Traffic Impact Study_V1_Comments.pdf Markup Summary

ct Analysis
PUDSP211
(4130)
.2022

RE: Wills at Clement to
El Paso County, Color
Traffic Impact Analy
LIC# K008130

Figure 2

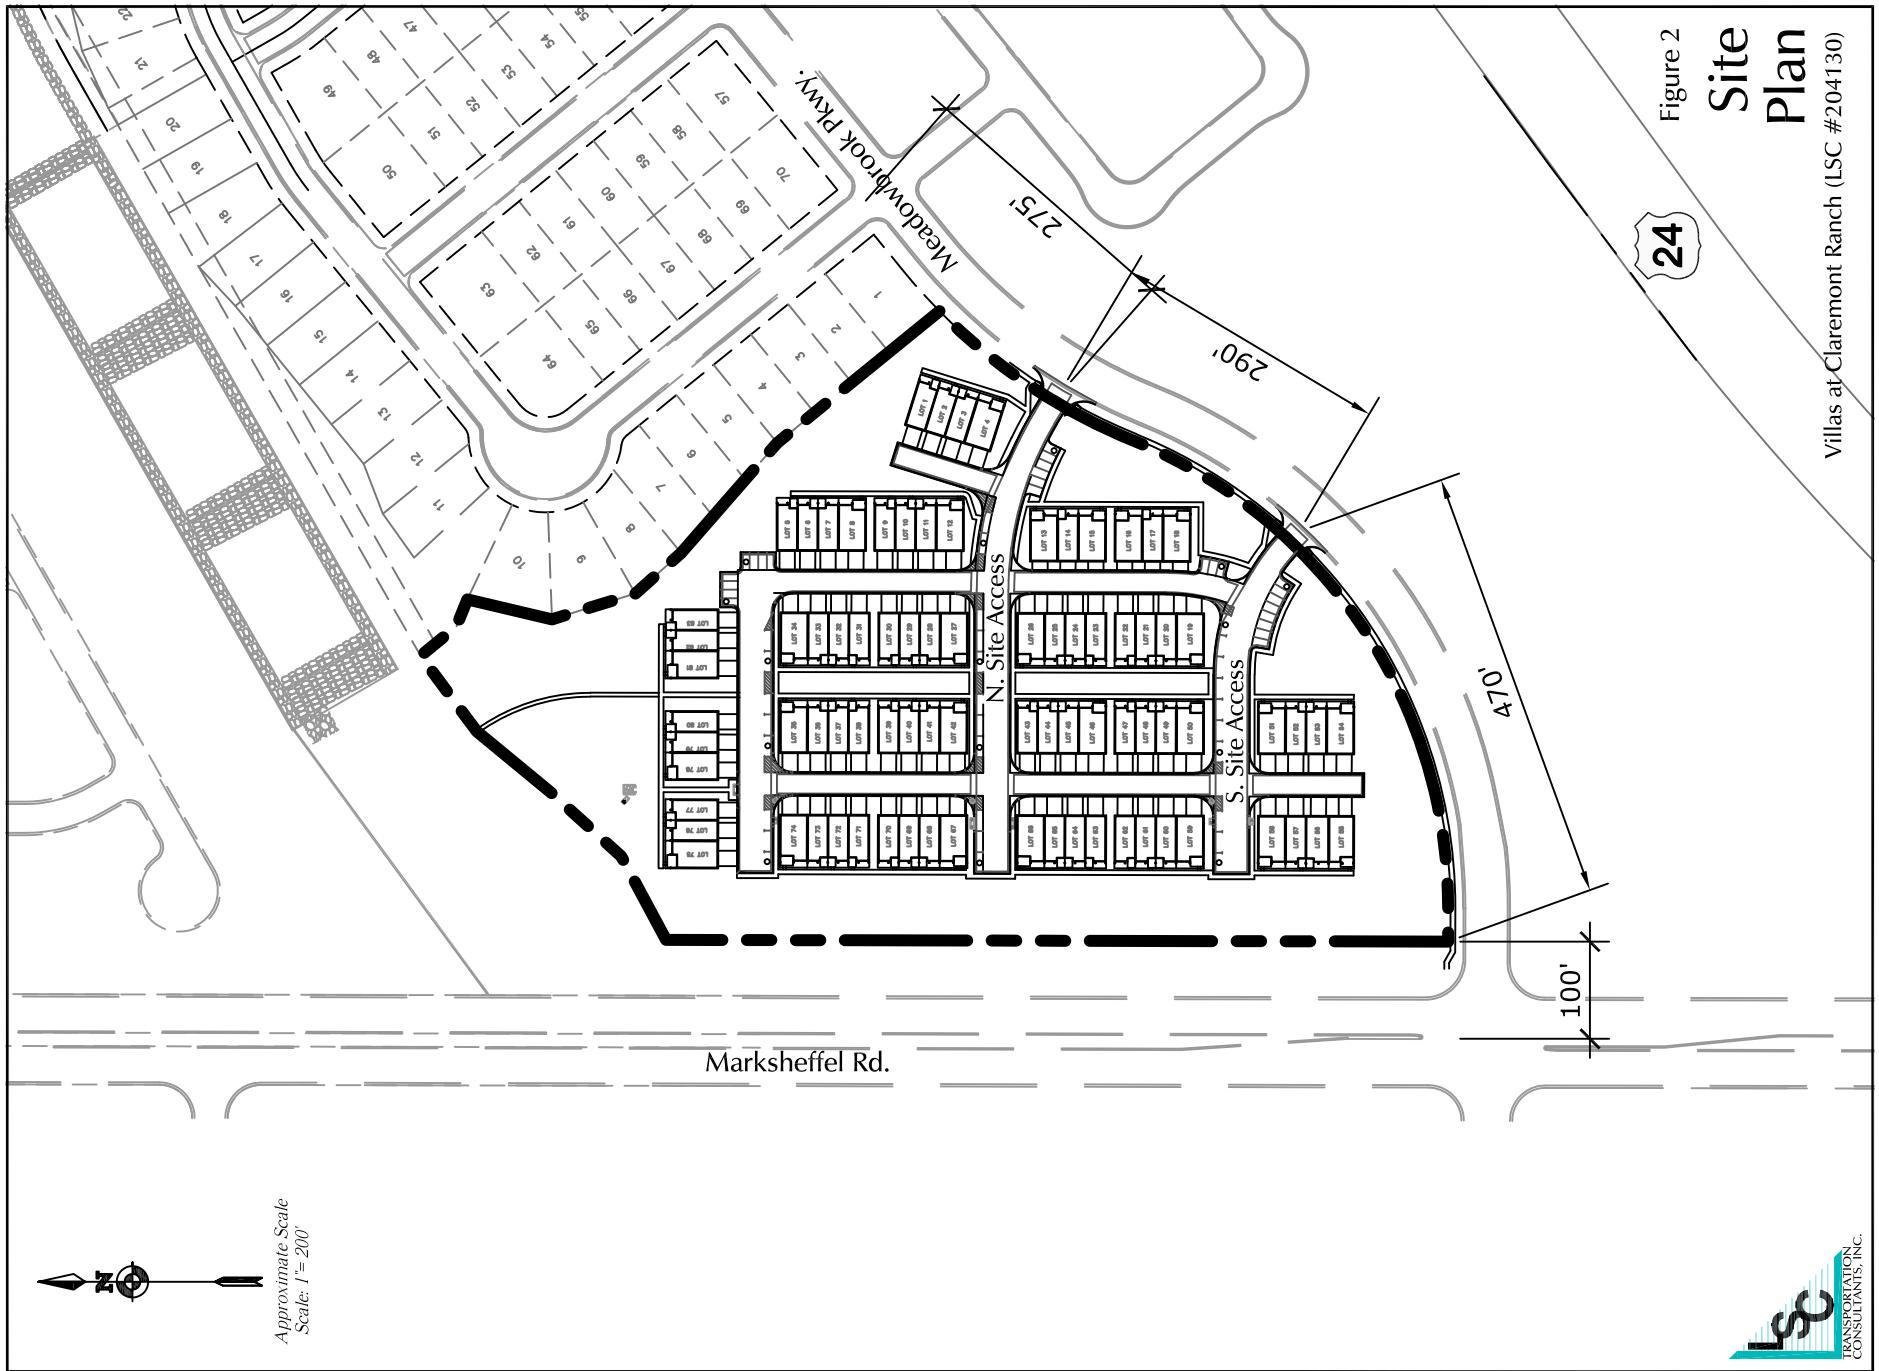
Figure 2 in appendix shows distances of 540' and 860' to proposed accesses.

Figure 10  
Conceptual Restriping Plan  
Meadowbrook Parkway  
Villas at Claremont Ranch (LSC #204130)

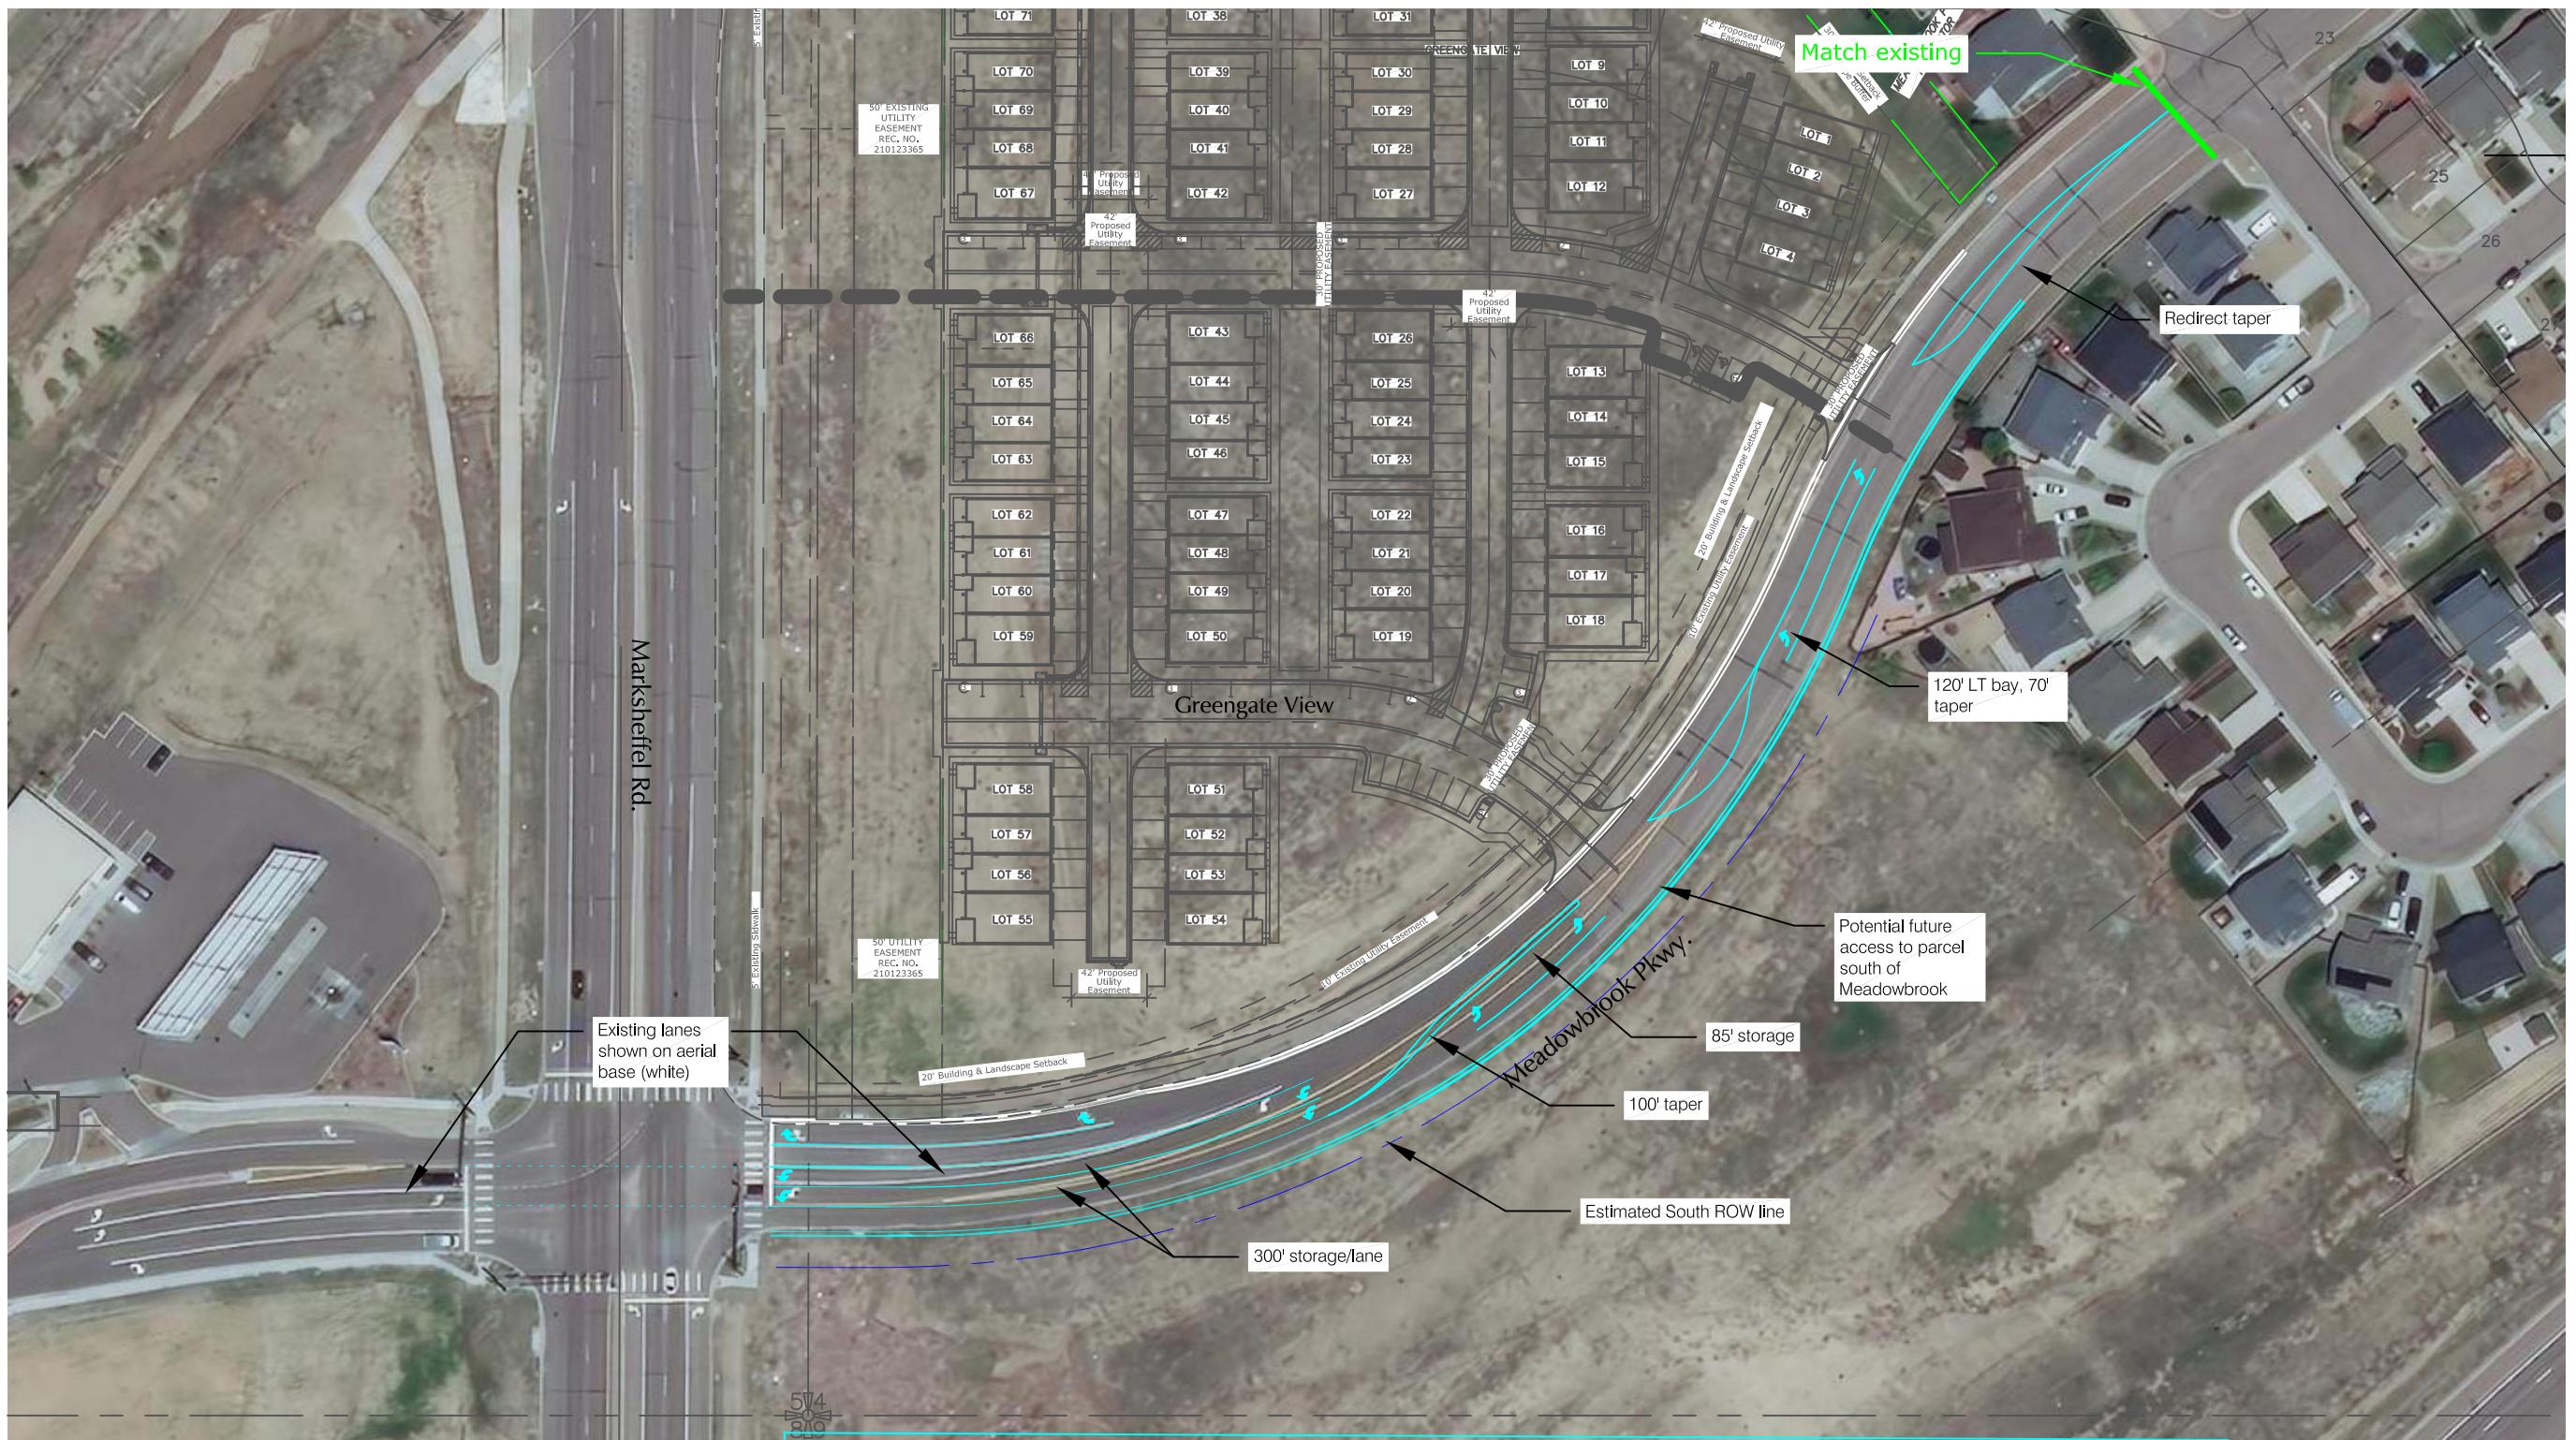
Update to street name
